## Comments on a planning application for land North Of Manor Farm. Noke

Reference number 22/01682/F

### Submission from Noke Parish Meeting

Noke Parish Meeting is **objecting** to this planning application

Cross Section

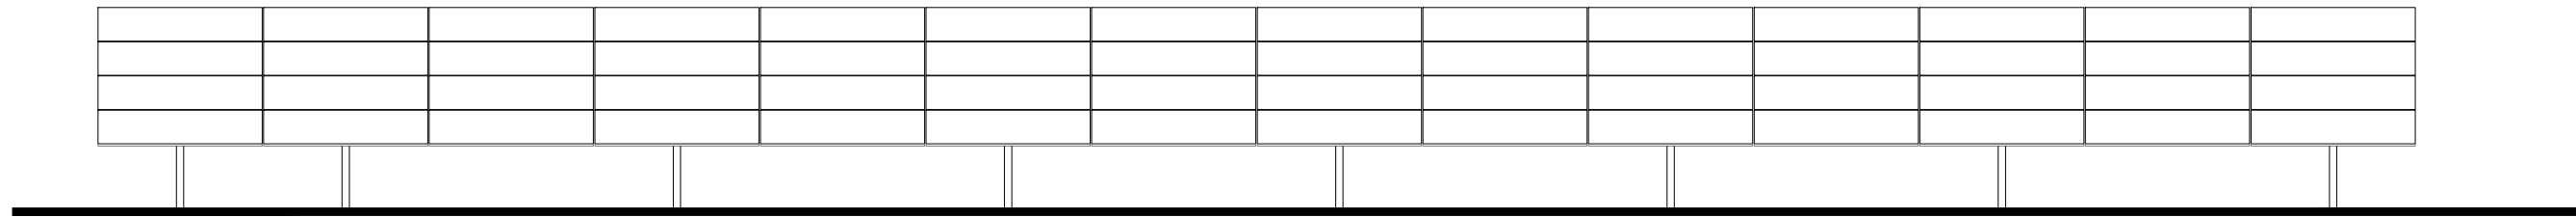
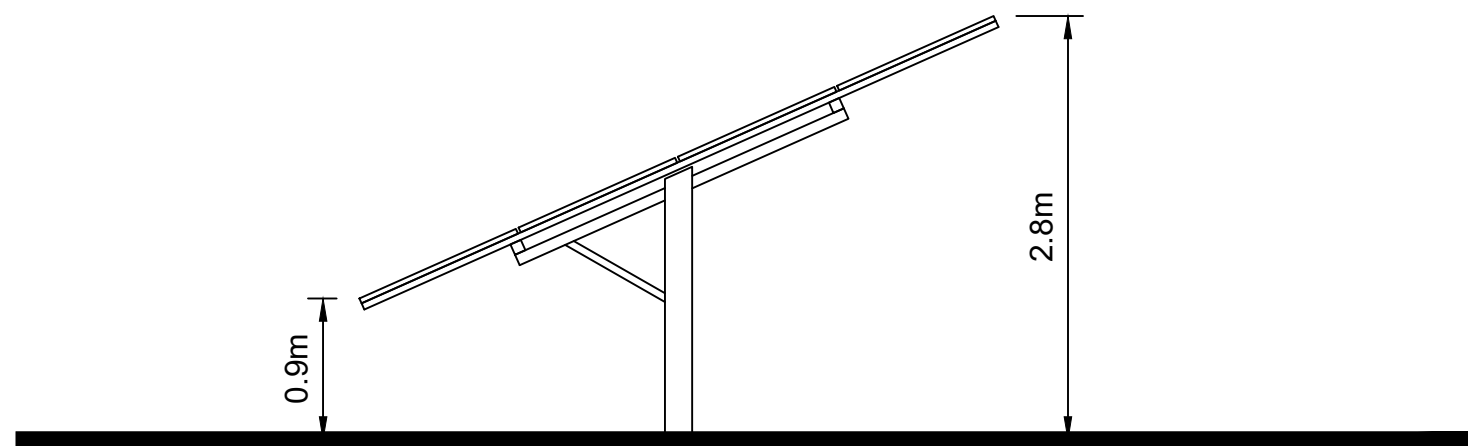
5. The plan indicates sheep could be grazed under and around the panels as a justification of continued agricultural use. It is not clear if this would be a planning condition. Local sheep farmers have thrown doubt on the viability of this plan on sheep welfare grounds.

Fence Elevation

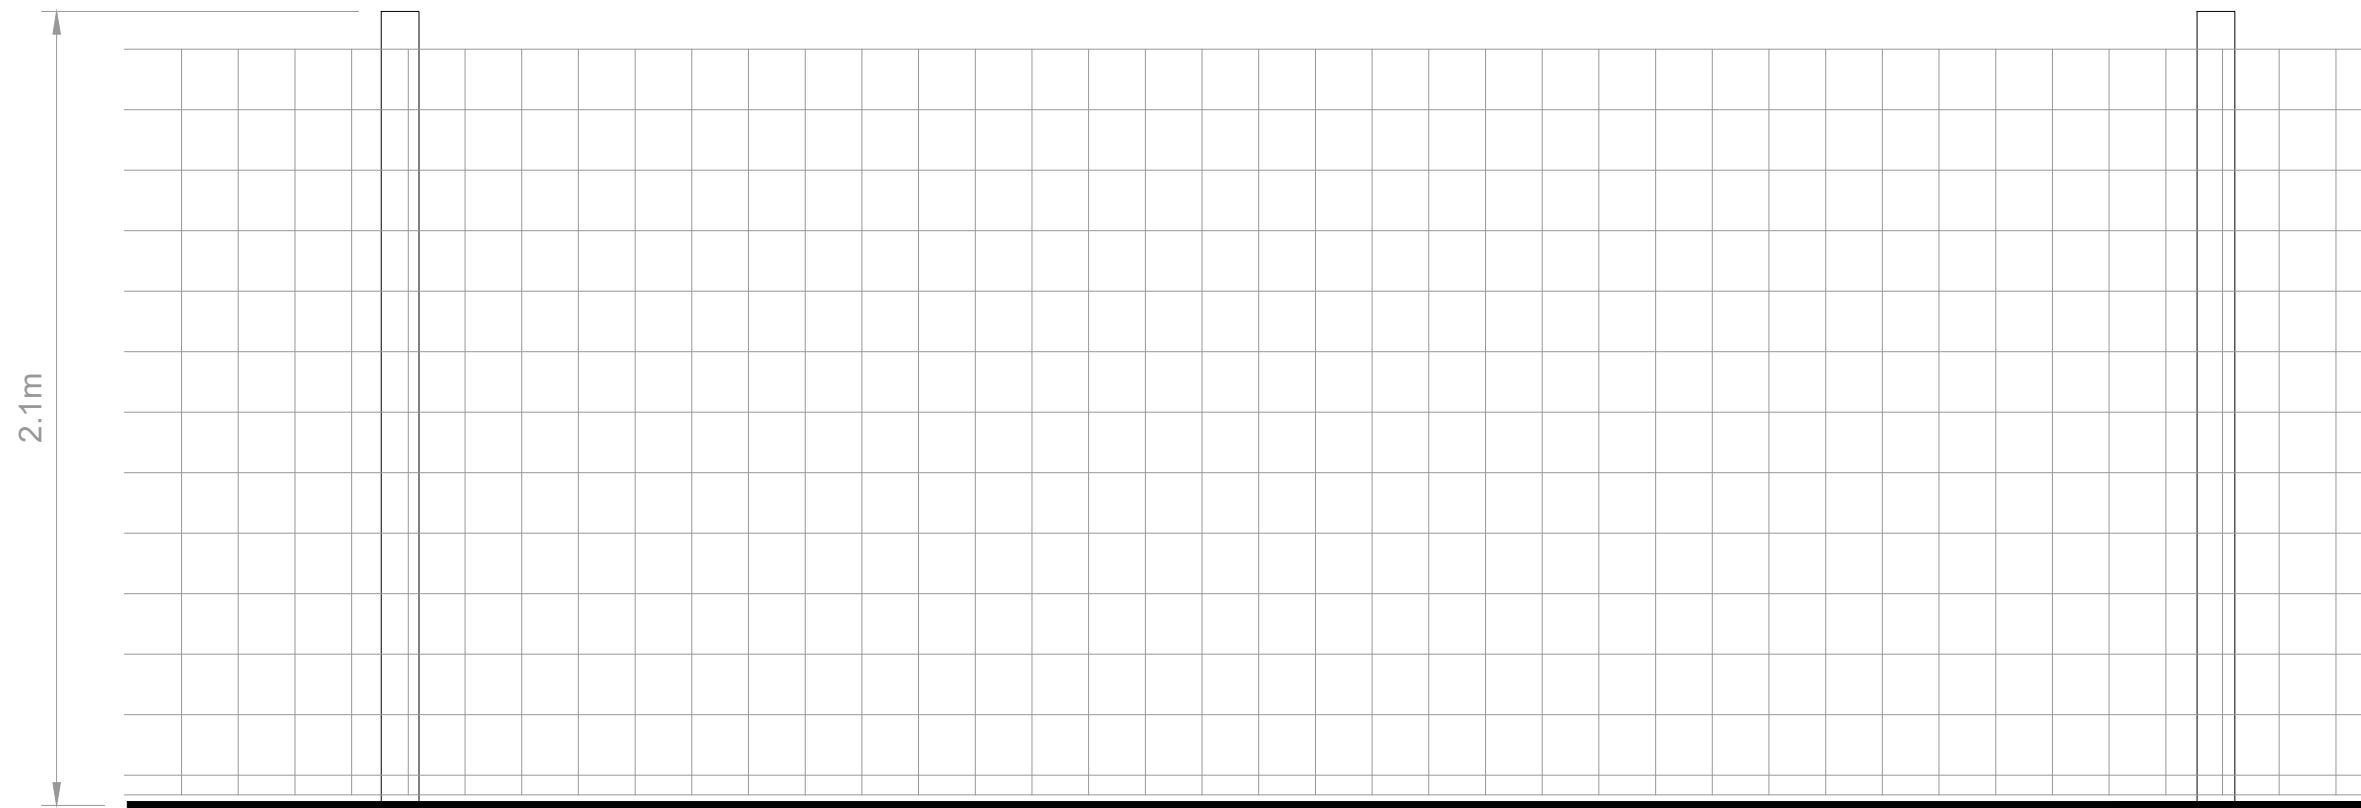
4. We note that the proposal has responded to concerns by widening the footpath to up to 50m in some places. This is of course welcome. However there will still be 2.8m high (approximately 9 feet) stock proof fencing and plant screening to interrupt views.
